From: Sarah Burrow <Sarah.Burrow@arun.gov.uk>
Sent: 11 March 2021 09:12
To: Anita Gardner <Anita.Gardner@arun.gov.uk>
Cc: Planning.Responses <Planning.Responses@arun.gov.uk>
Subject: EP/10/21/PL - Engineers Consultation Response

Engineers Comments Regarding Surface Water Drainage

18 BEECHLANDS COURT, EAST PRESTON, BN16 1JZ	
Client	Description
c/o RSP ARCHITECTS LTD	PROPOSED SITE PLAN

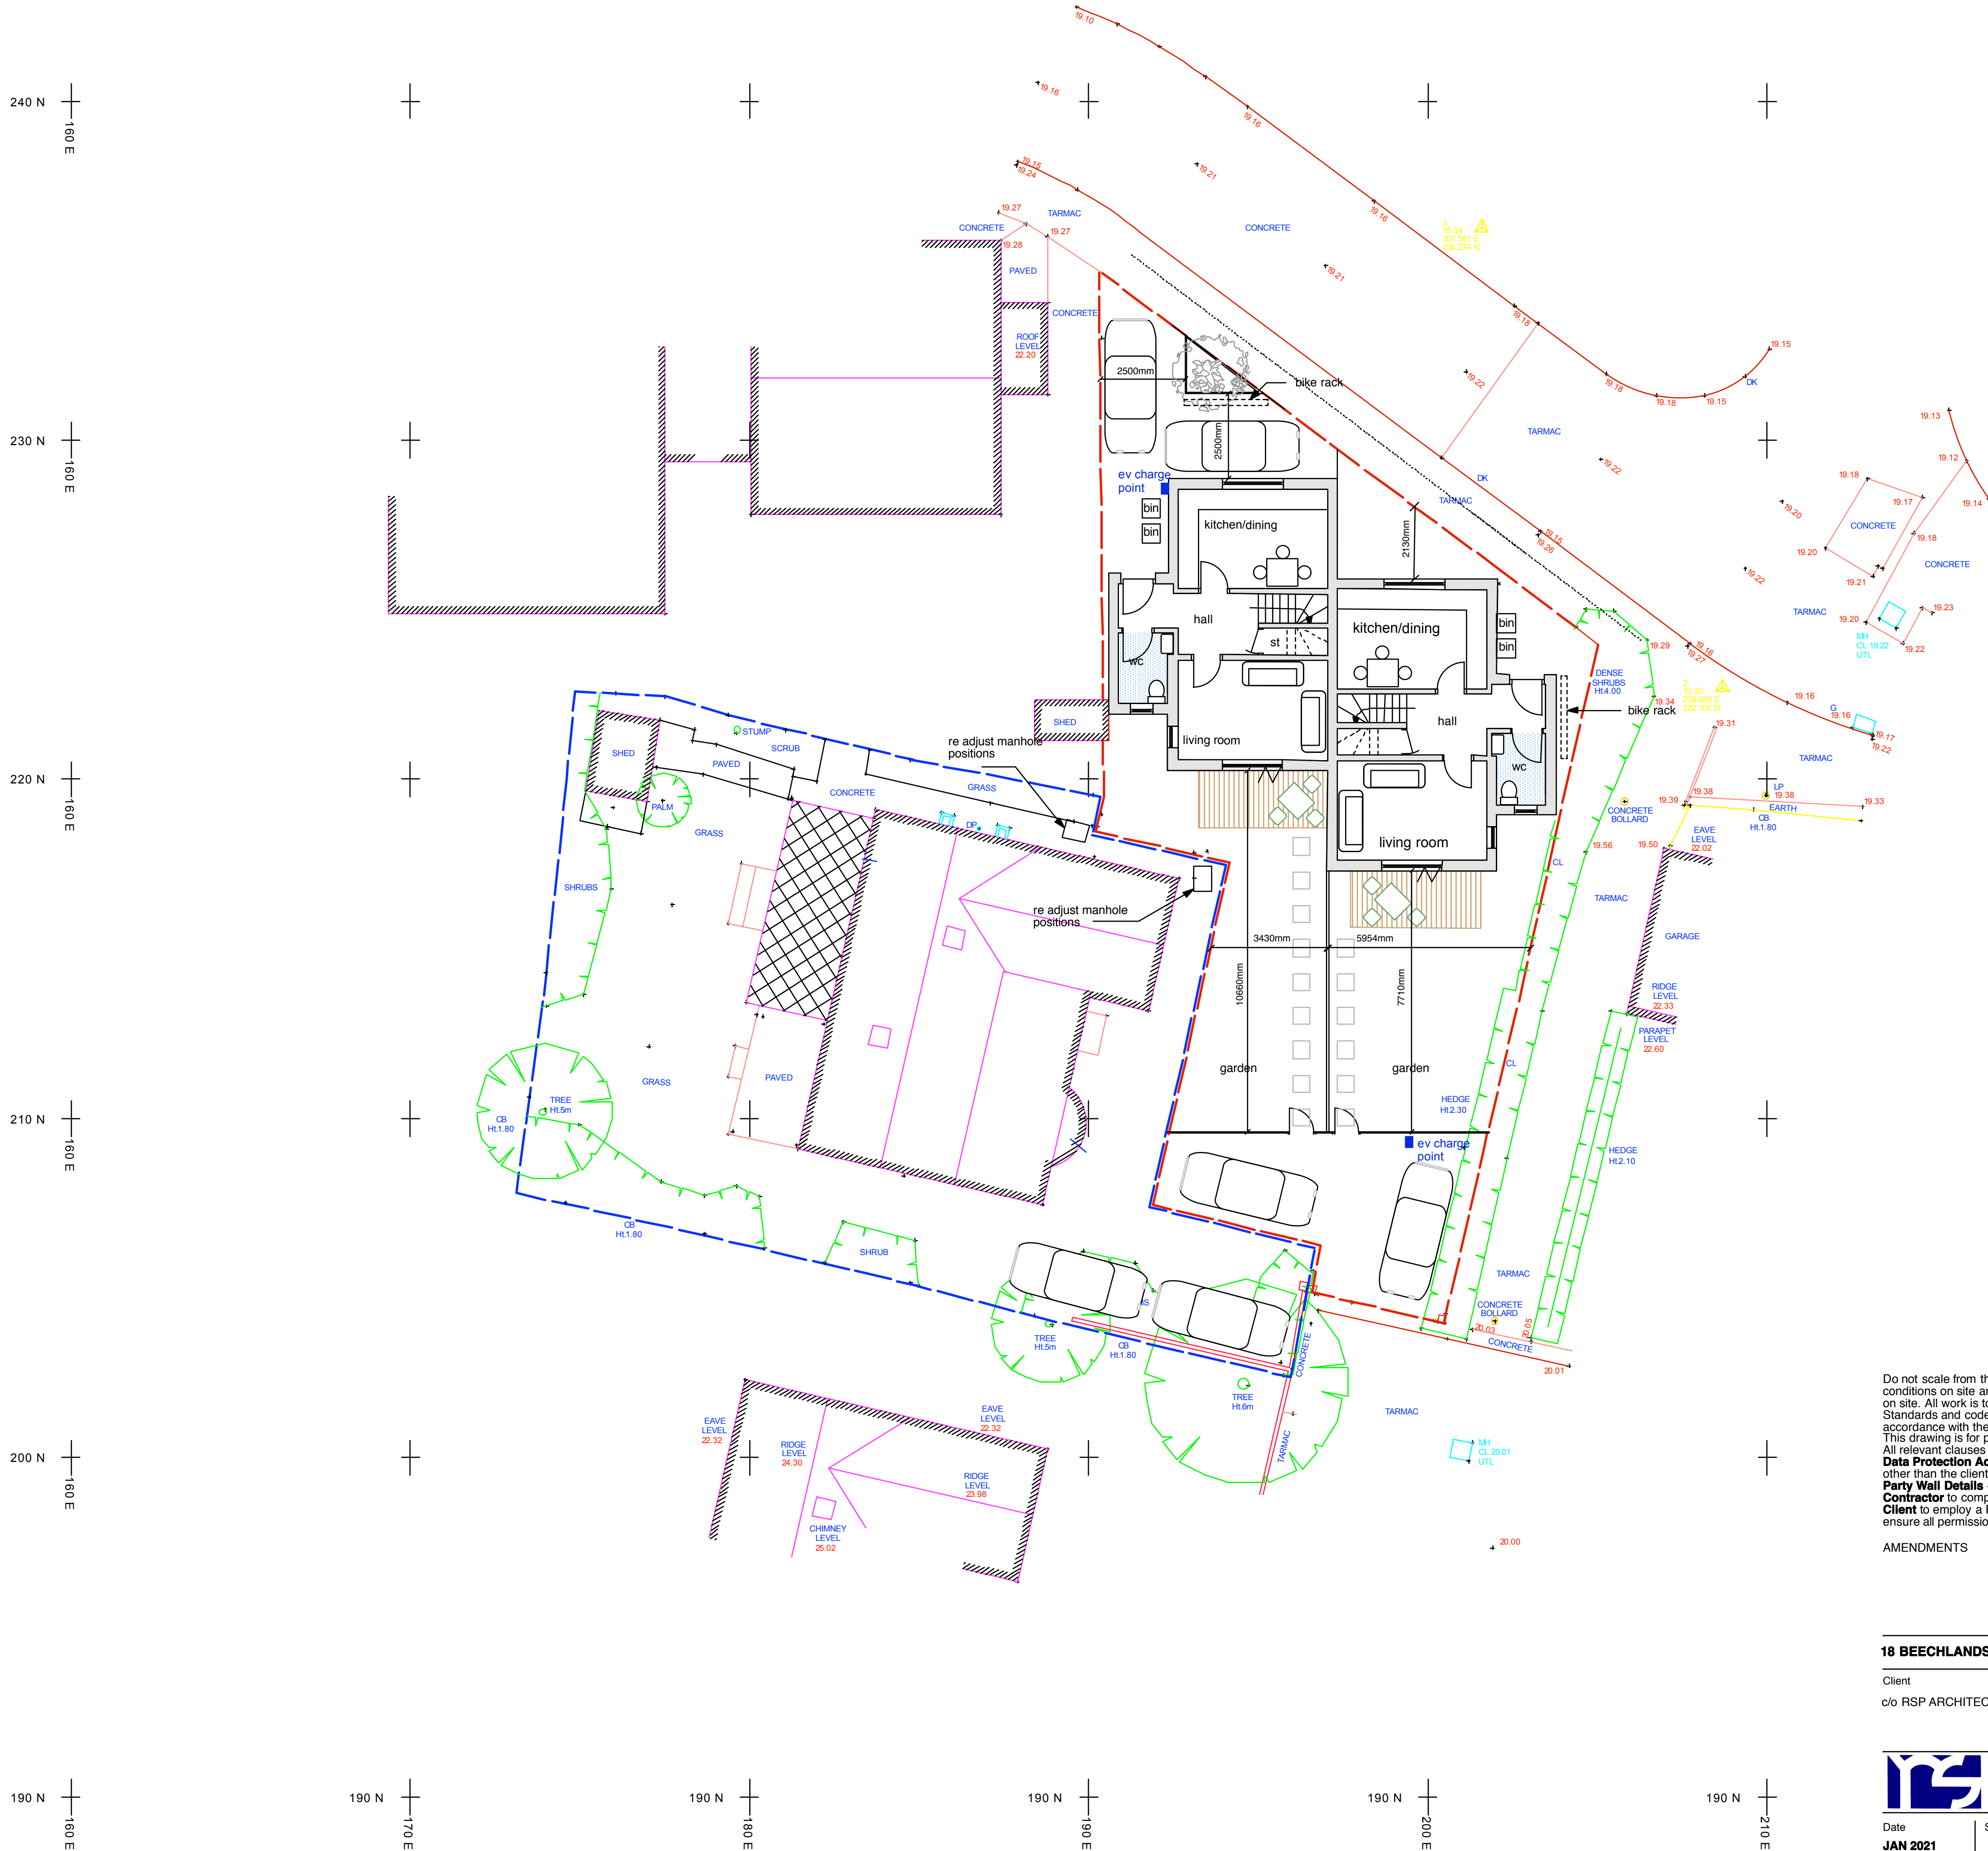
In this case, it is clear from the dimensions shown on the site layout that it will not be possible to locate a soakaway within the boundary of the western unit, it is also unlikely that a soakaway could be provided in the eastern unit without a relaxation of our requirements relating to the proximity to the south boundary.

It is also worth noting that the site slopes from south to north, depending on the depth to groundwater this could make draining surface water to the south more challenging.

Not utilising infiltration due to lack of space is inappropriate, this proposal unduly prejudices drainage design and is likely to not allow for the hierarchy for sustainable drainage to be followed. *There are no ordinary watercourses within or adjacent to the site, if infiltration is unviable due to inadequate space the water would have to go to foul sewer, it is unlikely this would be acceptable to Southern Water and therefore there would be a significant risk that the application would not be implementable.*

In order to remove my objection the applicant will need to supply winter groundwater monitoring, infiltration testing and a drainage design that shows that it is possible to meet our requirements and drain surface water from the site without increasing flood risk elsewhere. If the applicant proposes a shared soakaway or alternative shared infiltration system then they must show who will be responsible for the maintenance and management of that system in a maintenance and management manual (to be agreed via condition).
